WEST SUSSEX COUNTY COUNCIL CONSULTATION

TO:	Arun District Council FAO: Simon Davis
FROM:	WSCC - Highways Authority
DATE:	21 January 2021
LOCATION:	Land at Street Buildings North End Road Yapton BN18 0DT
SUBJECT:	Y/146/20/RES Application for approval of reserved matters for the erection of 45 dwellings pursuant to Section 73 permission Y/13/18/PL (following the grant of outline planning permission Y/49/17/OUT) (resubmission following Y/39/20/RES). This application may affect the setting of a Listed Building.
DATE OF SITE VISIT:	n/a
RECOMMENDATION:	Advice
S106 CONTRIBUTION TOTAL:	n/a

Title:
PLANNING LAYOUT

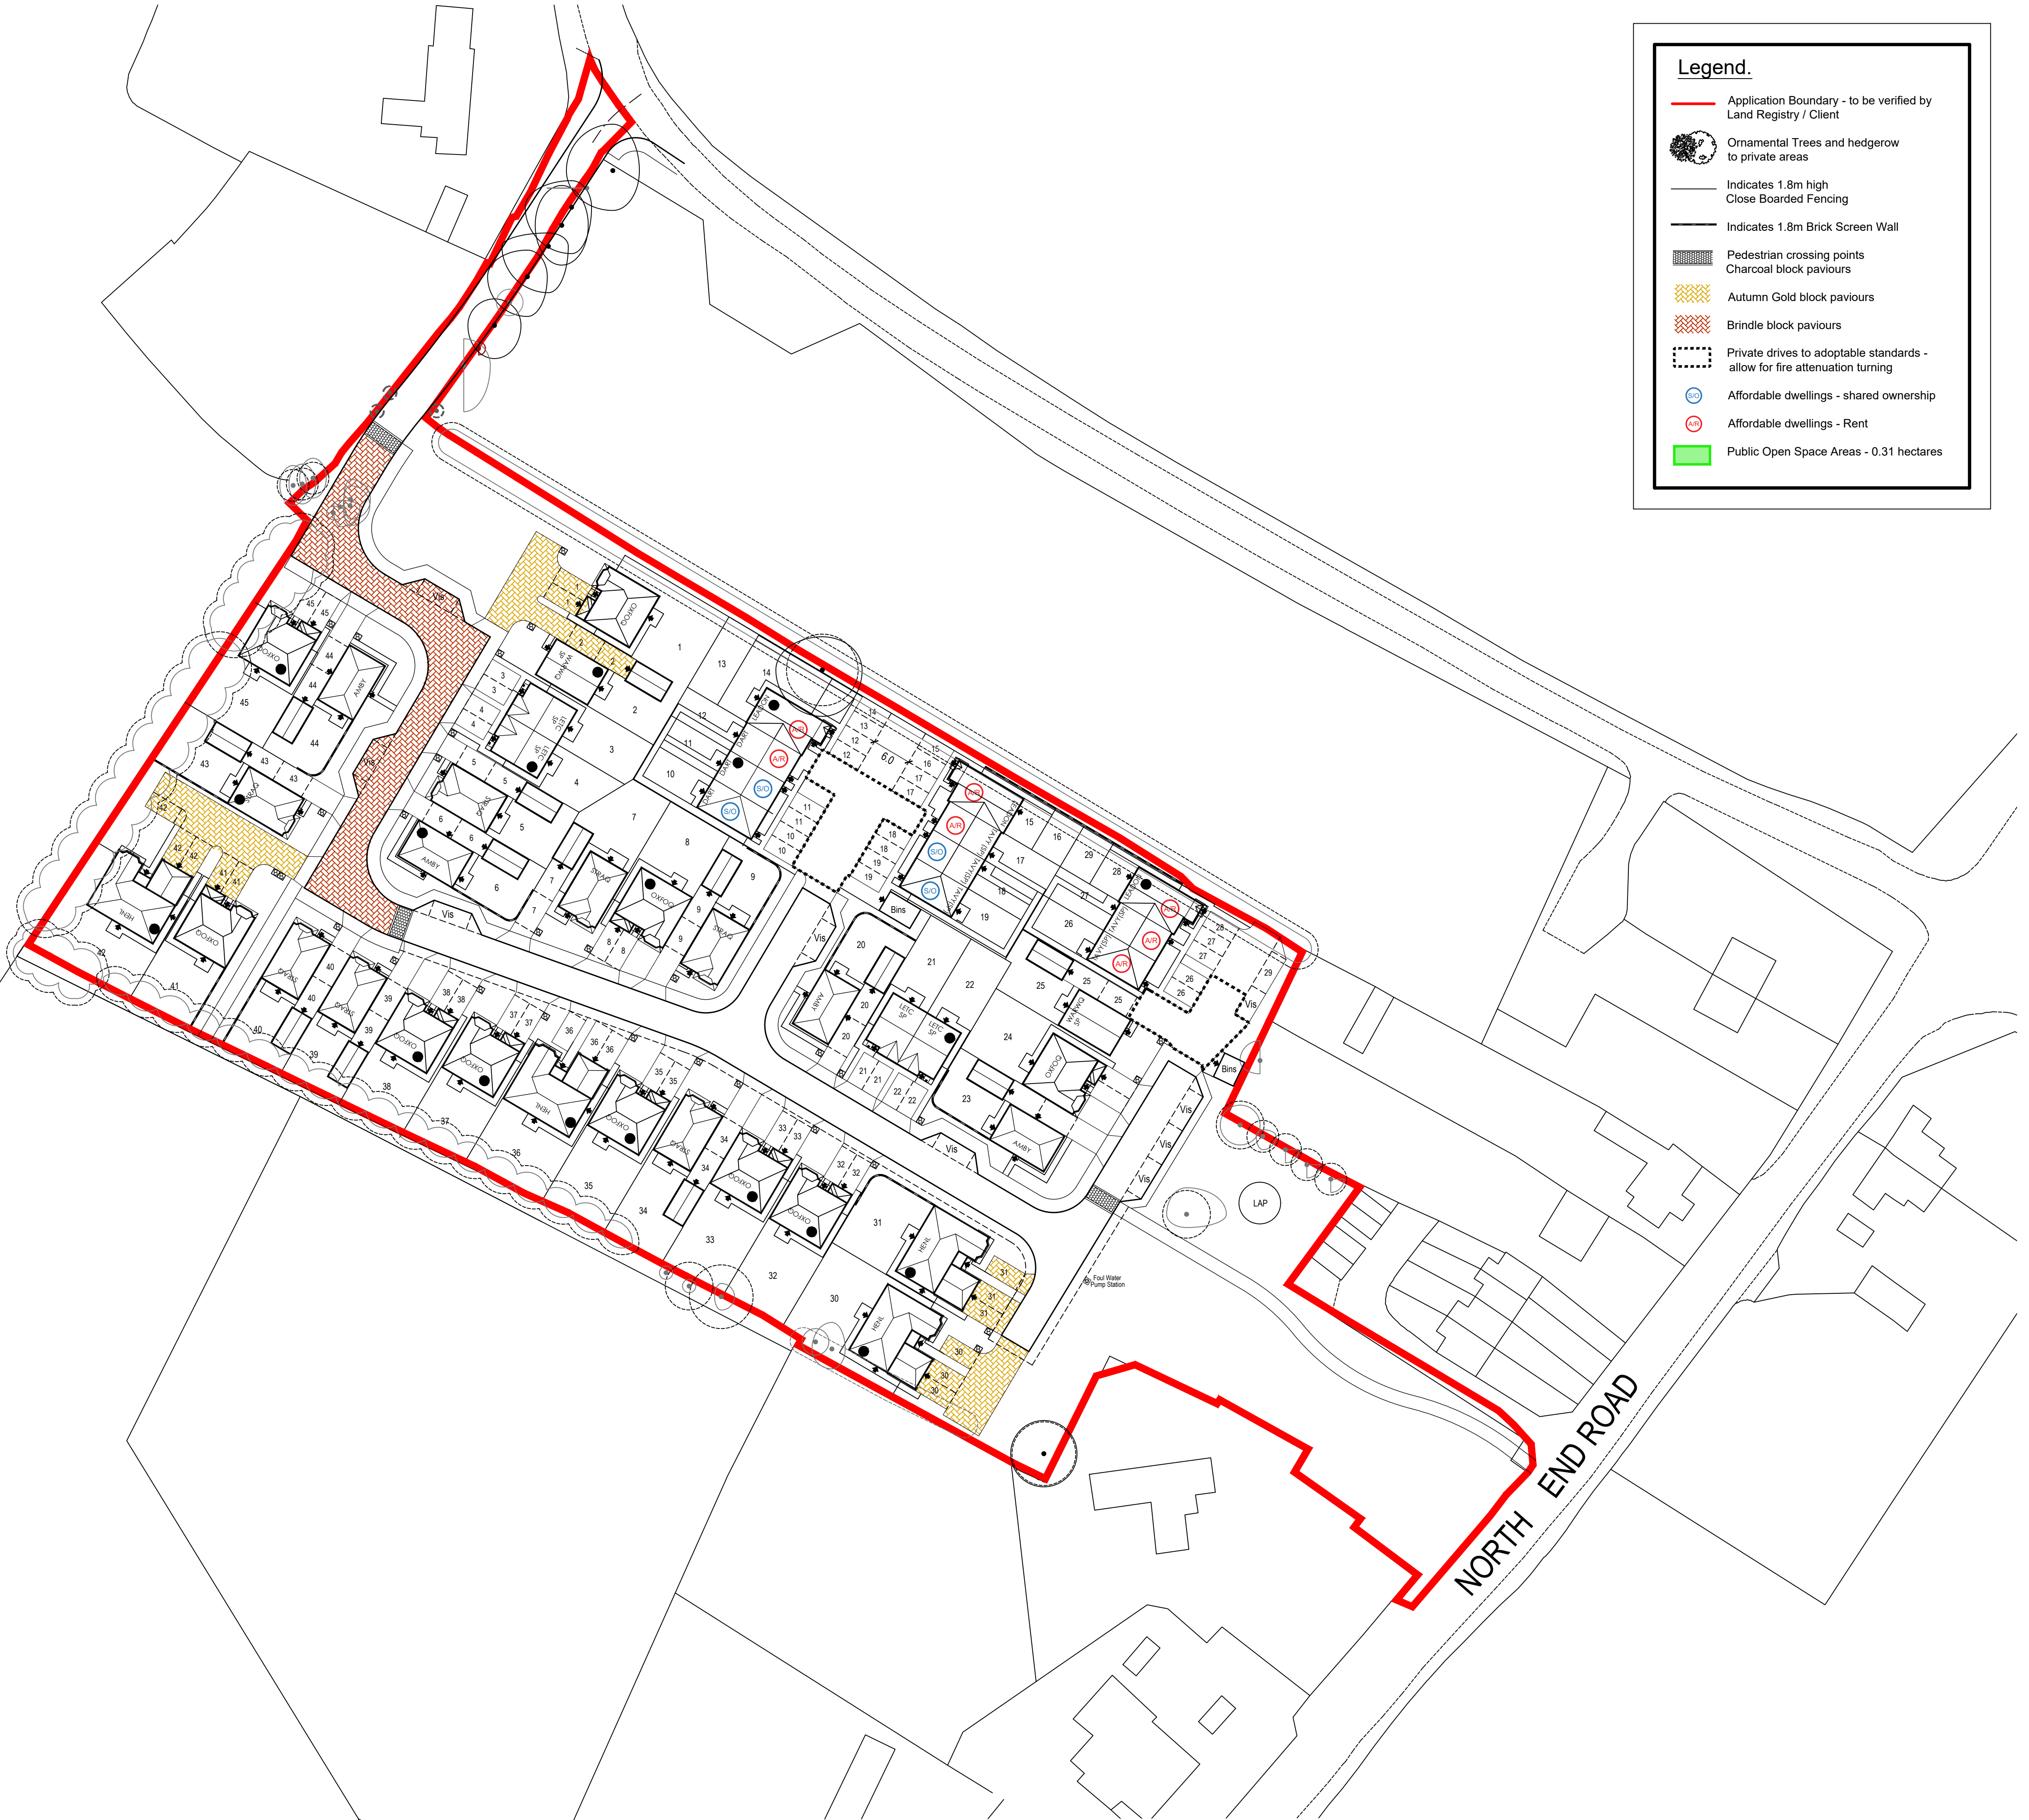
The Local Highway Authority (LHA) previously commented on these proposals in May 2020 under application Y/39/20/RES. Having assessed the information provided it would appear that our previous request for further information has not yet been addressed. This related to parking and confirming the parking is in line with the latest LHA parameters. It should be noted that the LHA's parking standards did alter in September 2020 and these latest standards should be used in conjunction with this application.
